From: Simon Davis
Sent: 16 January 2019 11:58
To: 'Dave Pearcey EI' [REDACTED]
Subject: RE: Bovis Homes - Burndell Road Y/98/18/RES

I don't consider that it would be necessary for them to submit a S.278 drawing with this application. Detail of access were approved by Y/19/16/OUT and there is a plan on that file that shows the improvements to the access. Y/98/18/RES is only seeking approval of layout, landscaping, scale and appearance therefore I see no need for a S.278 drawing to be provided that shows works to the highway. Furthermore, my understanding is that the S.278 process is separate to planning permission and is dealt with by WSCC as the Highways Authority. If a S.278 is necessary then it would be for WSCC to consider this. You may therefore wish to get in touch with them.

Thank you for the prompt reply however dwg. 18-070-103A is the Preliminary Engineering drawing which mainly covers the site works etc. I have already looked at this drawing which formed part my concerns and objections.

Job Title			
LAND SOUTH OF BURNDILL ROAD, YAPTON			
Drawing Title			
PRELIMINARY ENGINEERING LAYOUT			
Client			
BOVIS HOMES			
Scale	Date	Designed	SG
1:500 @A1	NOV 18		
Drawn	Checked	Approved	RS
SOM	LH		
Job No	Drawing No		Rev
18-070	18-070/103		P

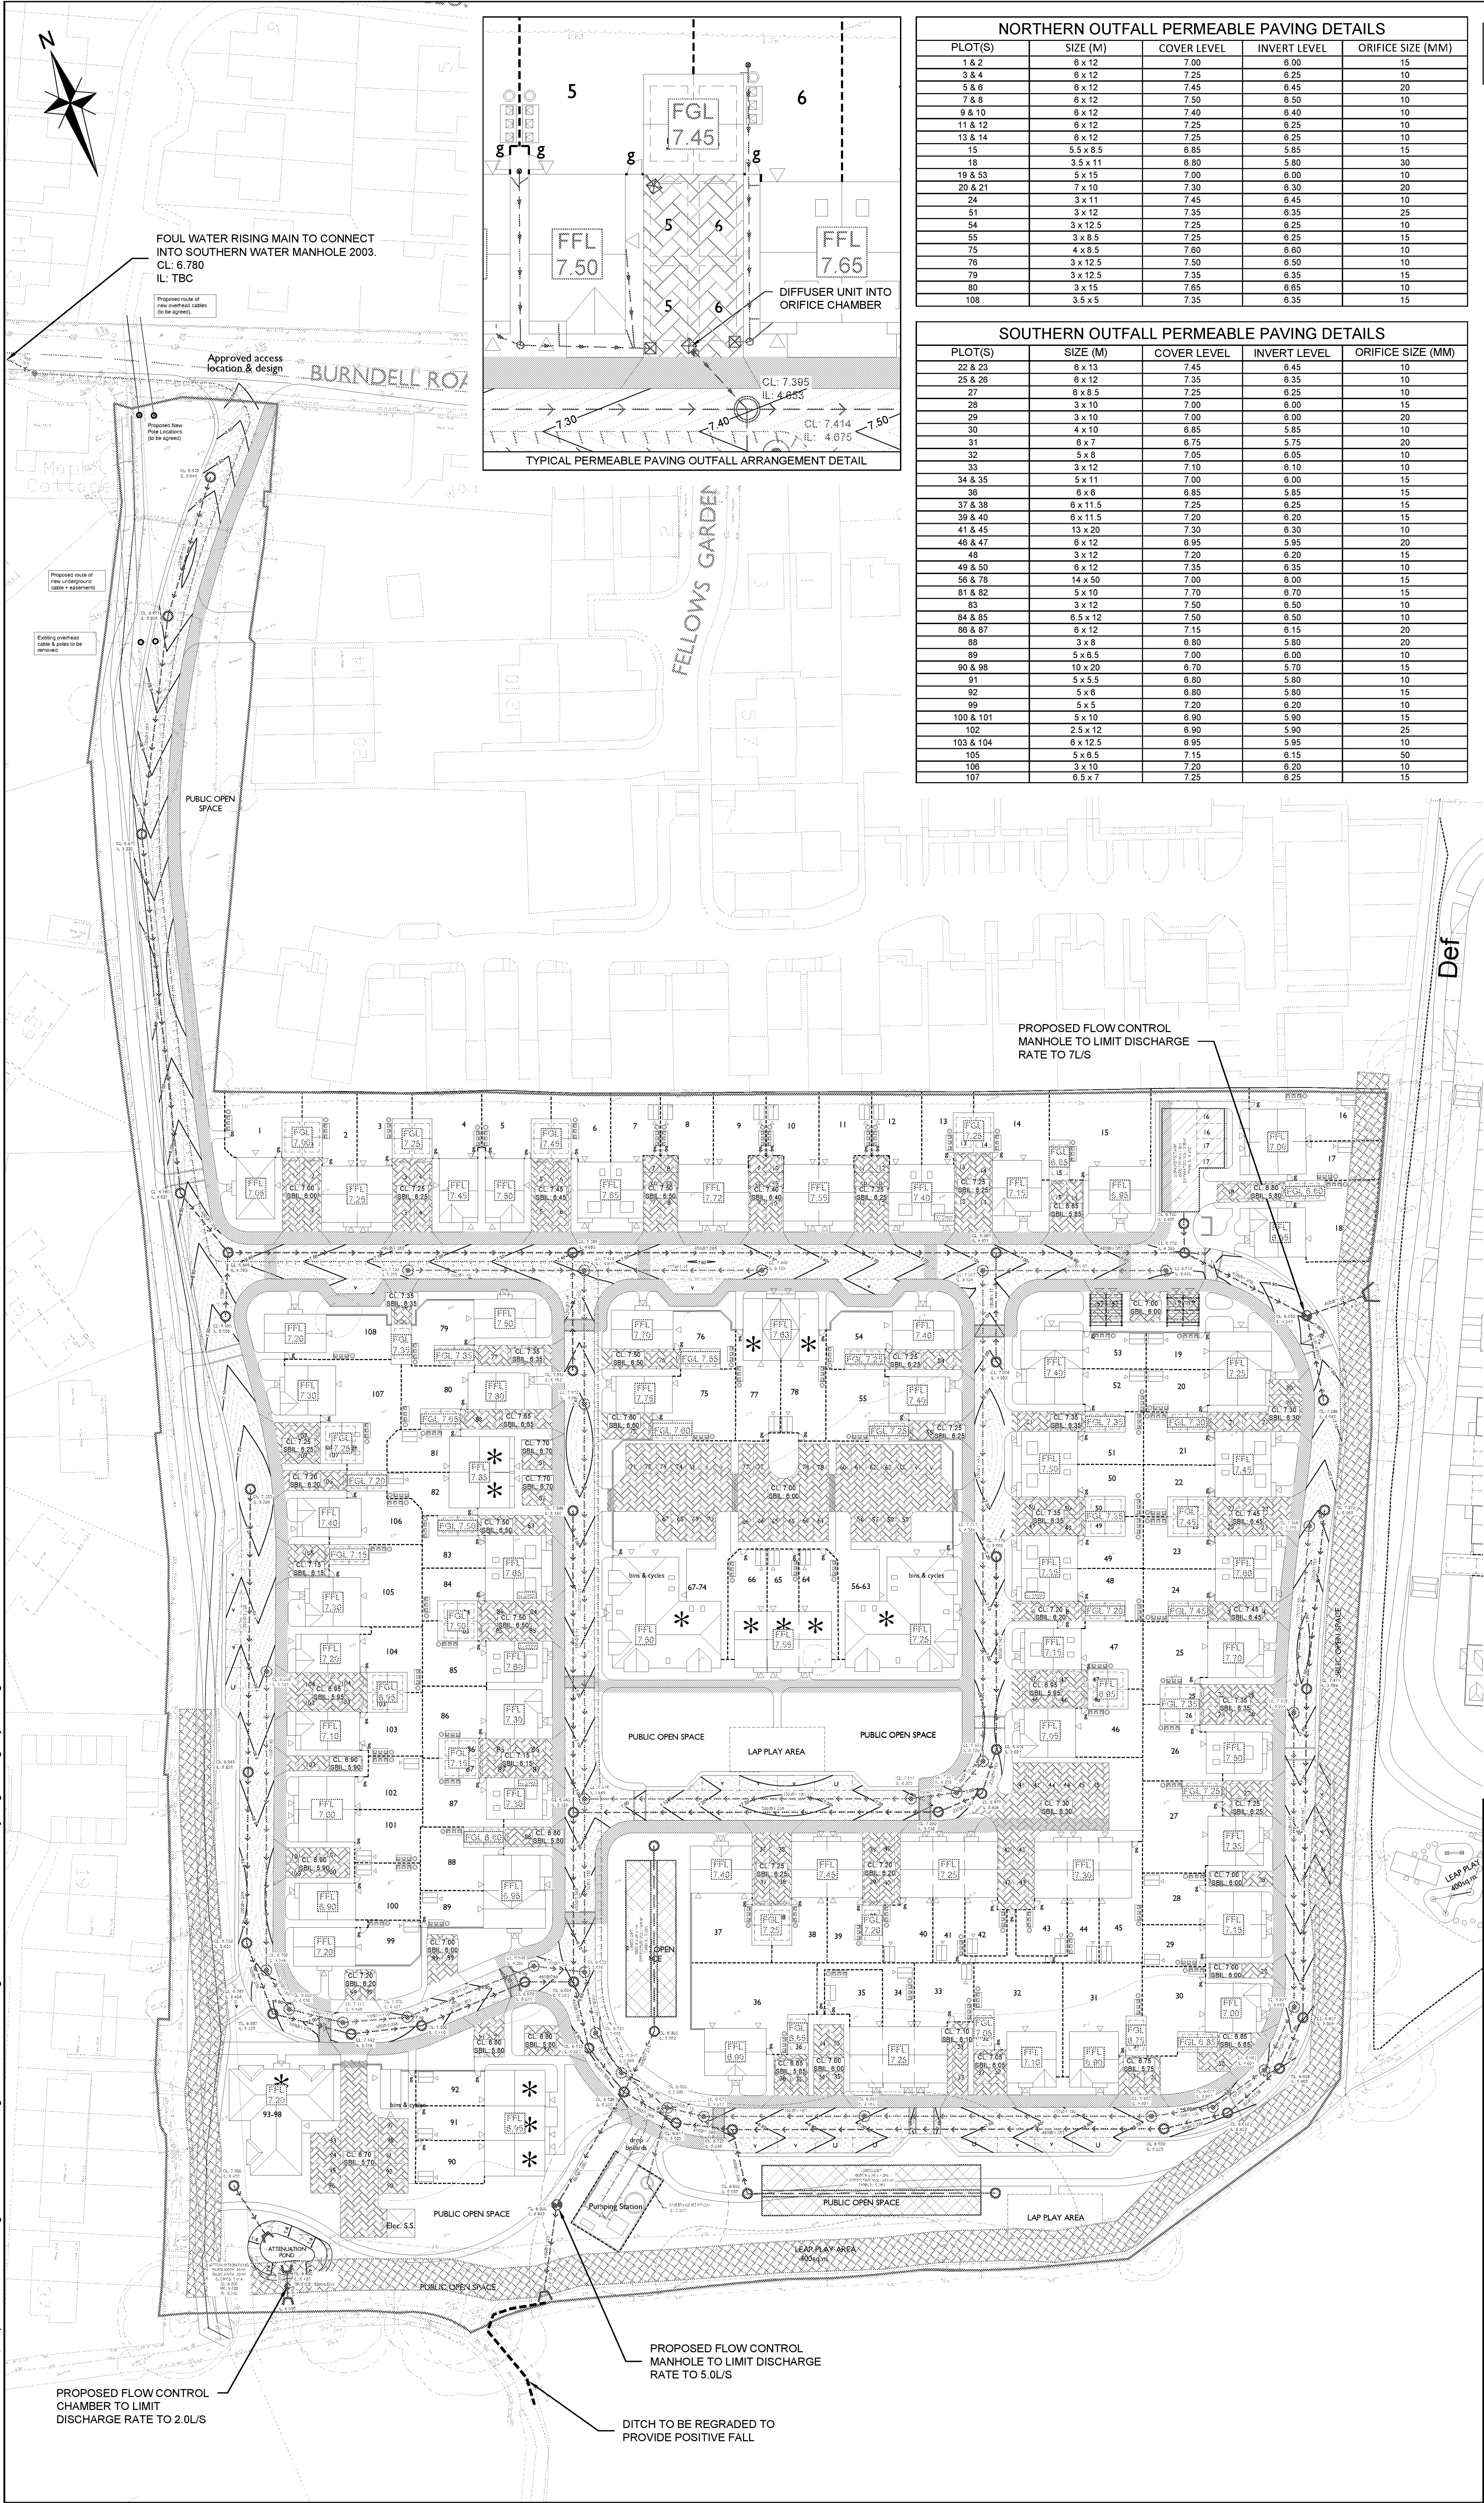
I was trying to find the WSCC Highways Section 278 technical approved drawing for the works on the public Highway, this will showing the kerb alignment changes, road markings and road signs, footway

construction and pedestrian crossing points, materials, carriageway tie and changes along with the street lighting positions.
